Medworth Energy from Waste Combined Heat and Power Facility

PINS ref. EN010110
Document Reference: Vol 9.20
Revision: 8.0
Deadline 8
August 2023

Schedule of Changes (Deadline 8)

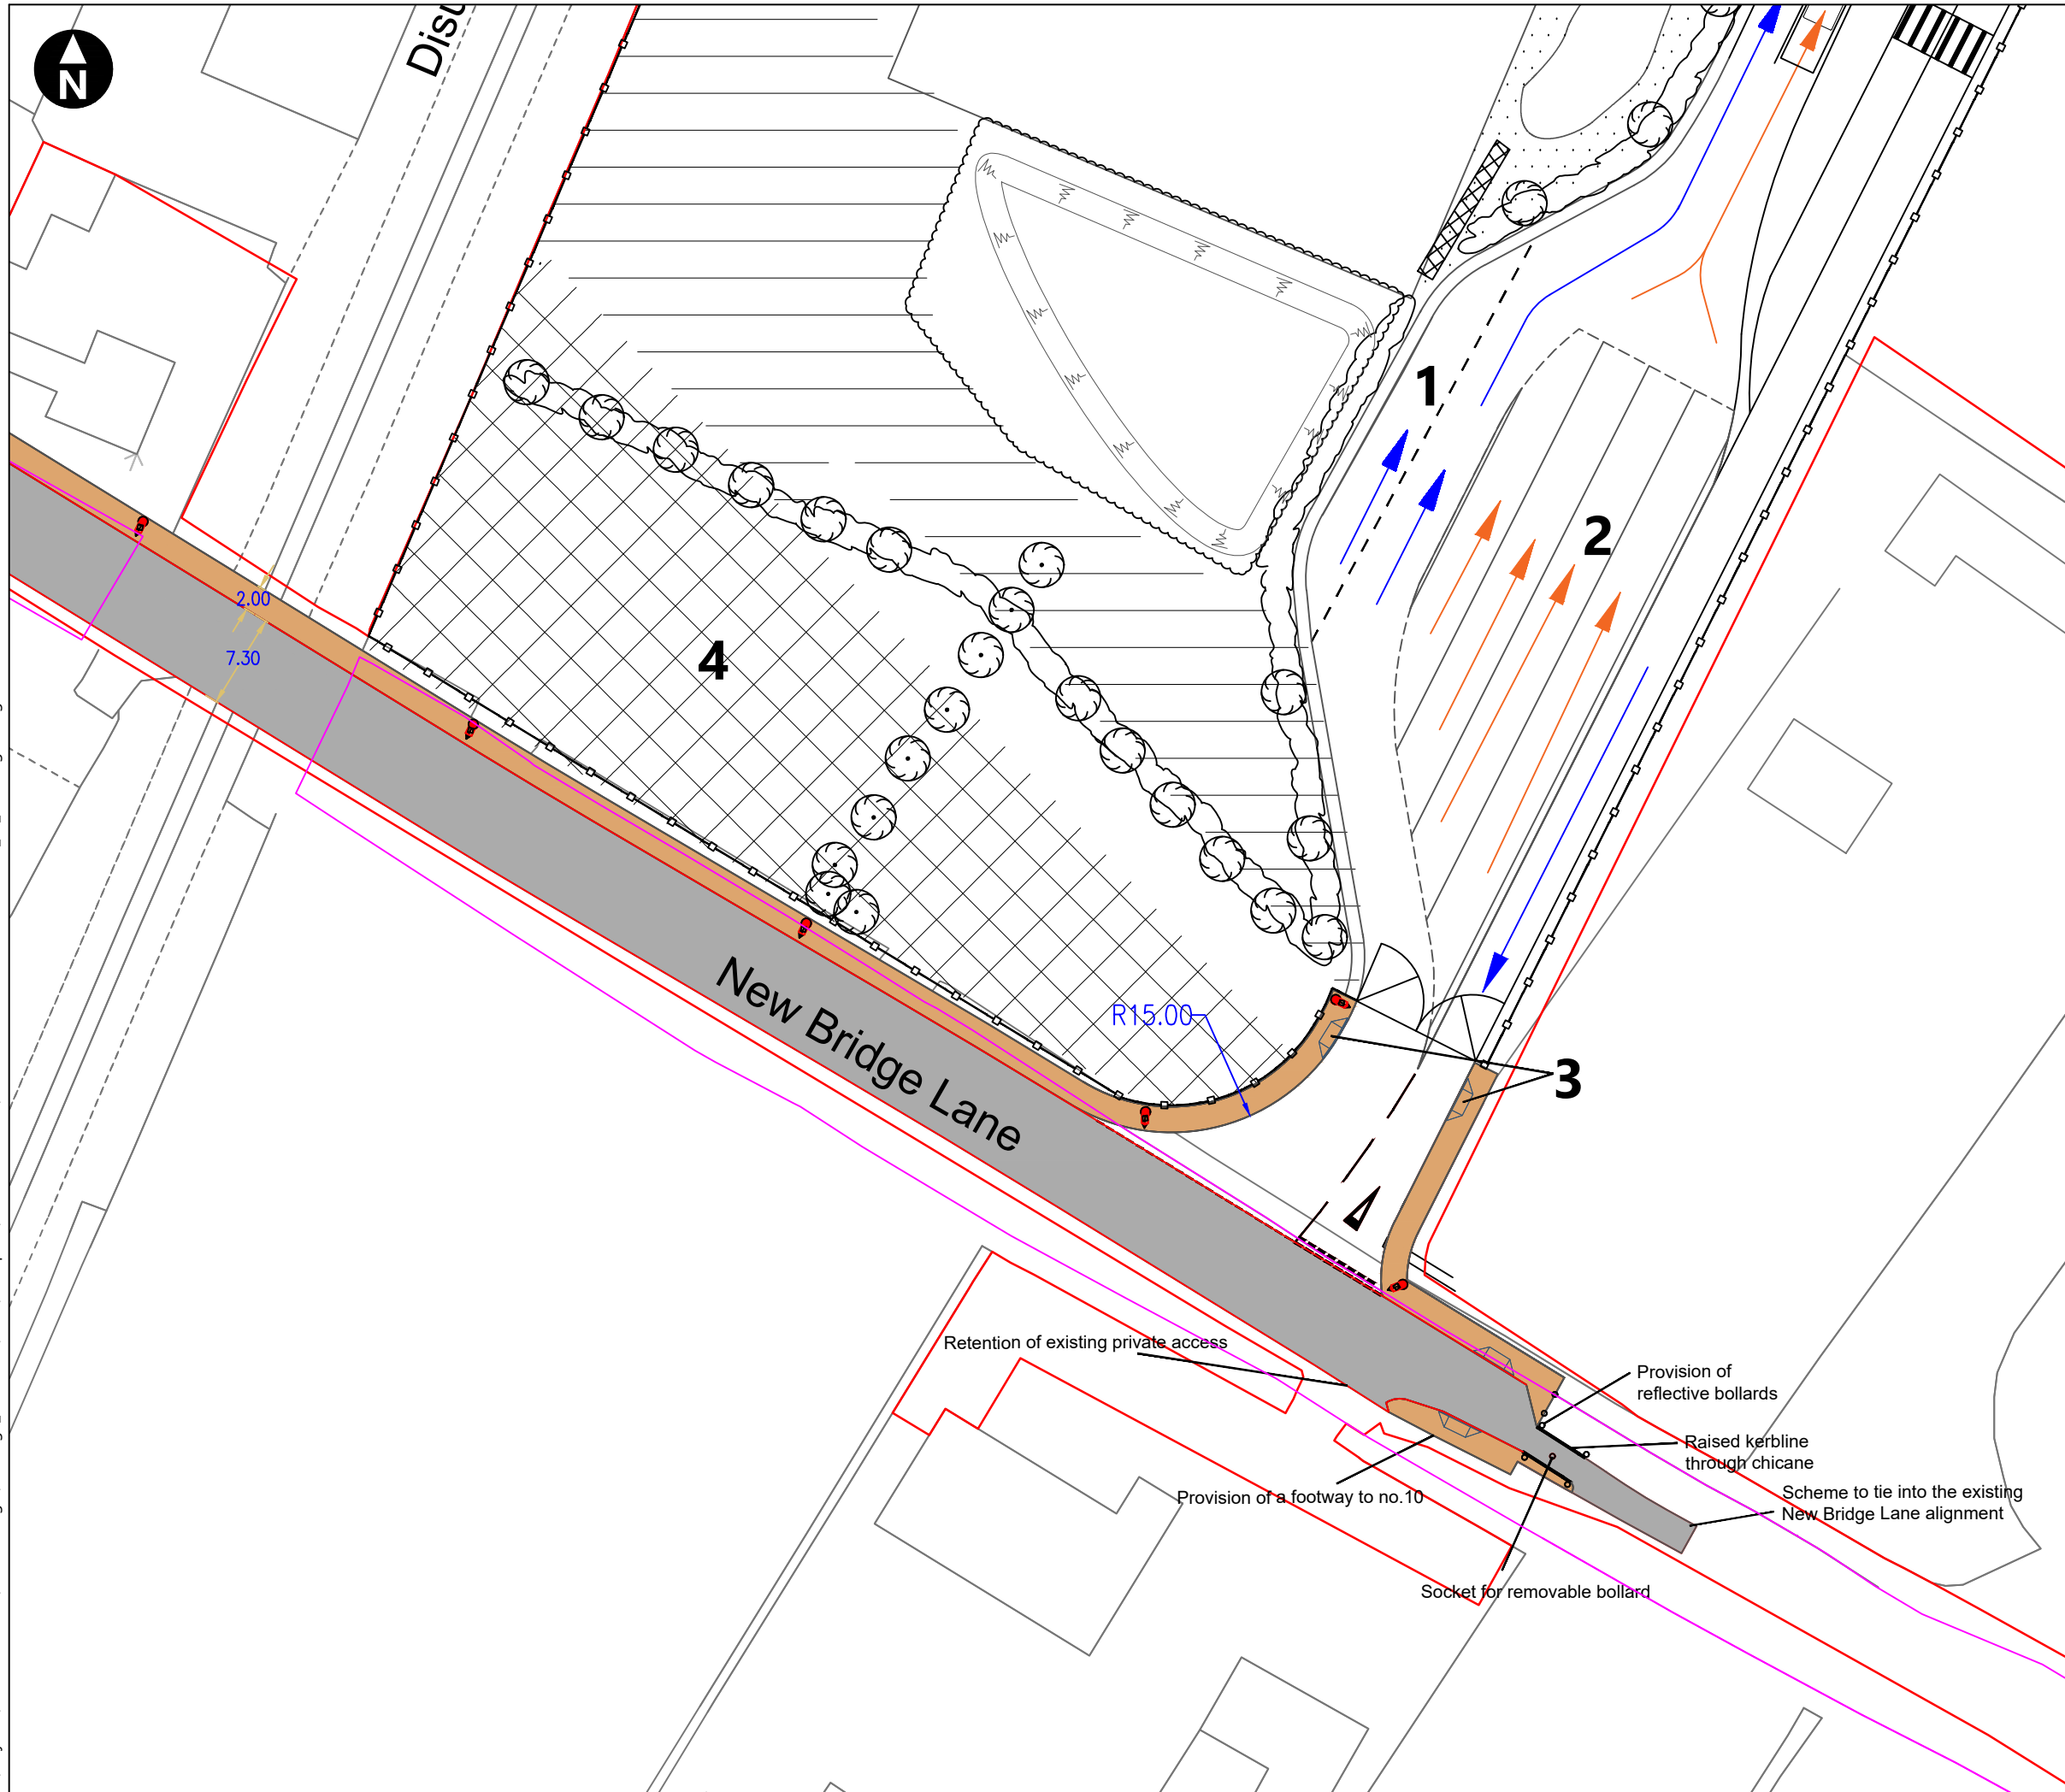
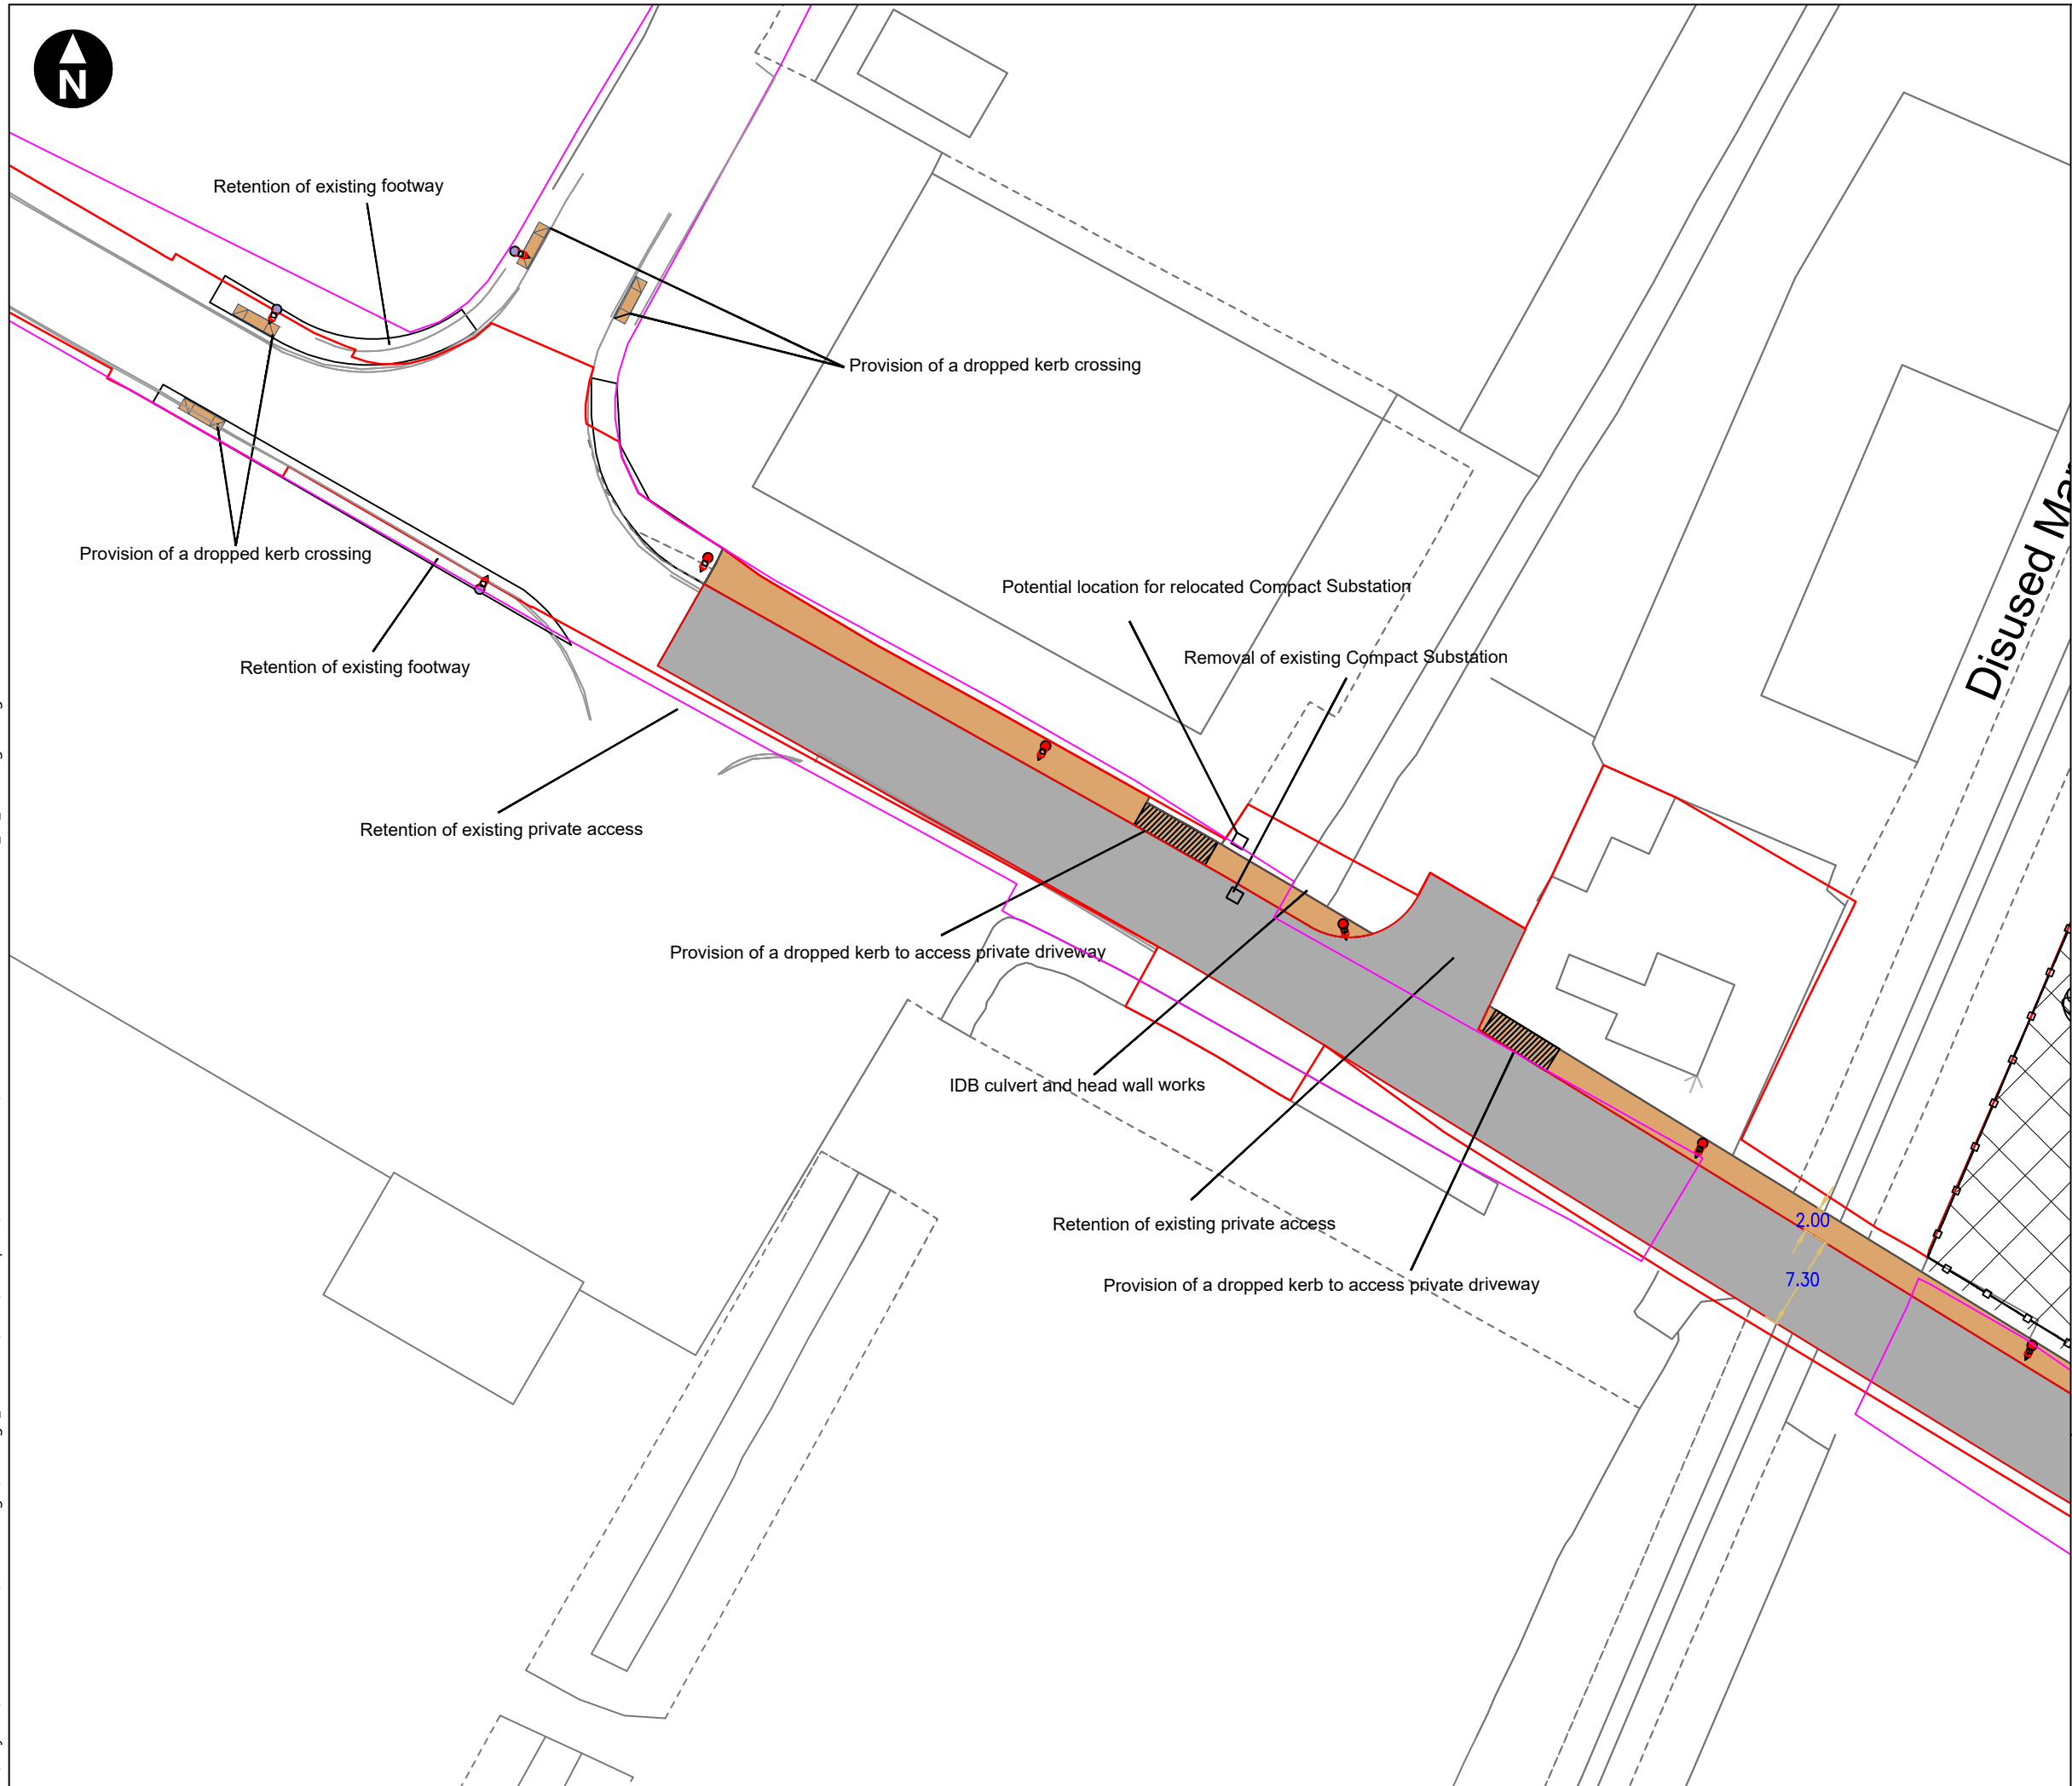
Volume 6.4 ES Chapter 6 Traffic	Additional drawings, Figures 9.2ii to show swept path of vehicle leaving New Bridge	CCC and FDC LIR paragraph 2.7.32 and 2.7.34 [REP1-074].	Deadline 3	Rev 3

Document Updated	Change	Reason for change	Deadline submitted	Relevant Document version
and Transport Appendix 6A Outline (CTMP) [REP1-011]	Lane. Also Figure 10.3i – ii to show outline design for construction accesses into the CHP Connection Corridor from Weasenham Lane and accompanying swept path.			
Volume 6.4 ES Chapter 7 Noise and Vibration Appendix 7D Operational NMP [REP1-012]	Reference to Applicant's intention to purchase 9 New Bridge Lane updated to confirm that the property has been purchased. Additional text added to 5.1.2 to include for the submission of a report to the relevant planning authority detailing the height, materials and acoustic performance of the acoustic fence to 10 New Bridge Lane for agreement ahead of construction.	CCC and FDC Comments on the Applicant's D1 Submissions (Outline CEMP) [REP2-031]. Outline Operational Noise Management Plan.	Deadline 3	Rev 3
Volume 6.4 ES Chapter 7 Noise and Vibration Appendix 7D Operational NMP [REP1-012]	New paragraphs 1.4.8 and 1.4.9 to provide a commitment to the preparation of an Operational Noise and Vibration Management Plan for the Walsoken Substation.	KLWN Relevant Representation [REP2-028].	Deadline 3	Rev 3
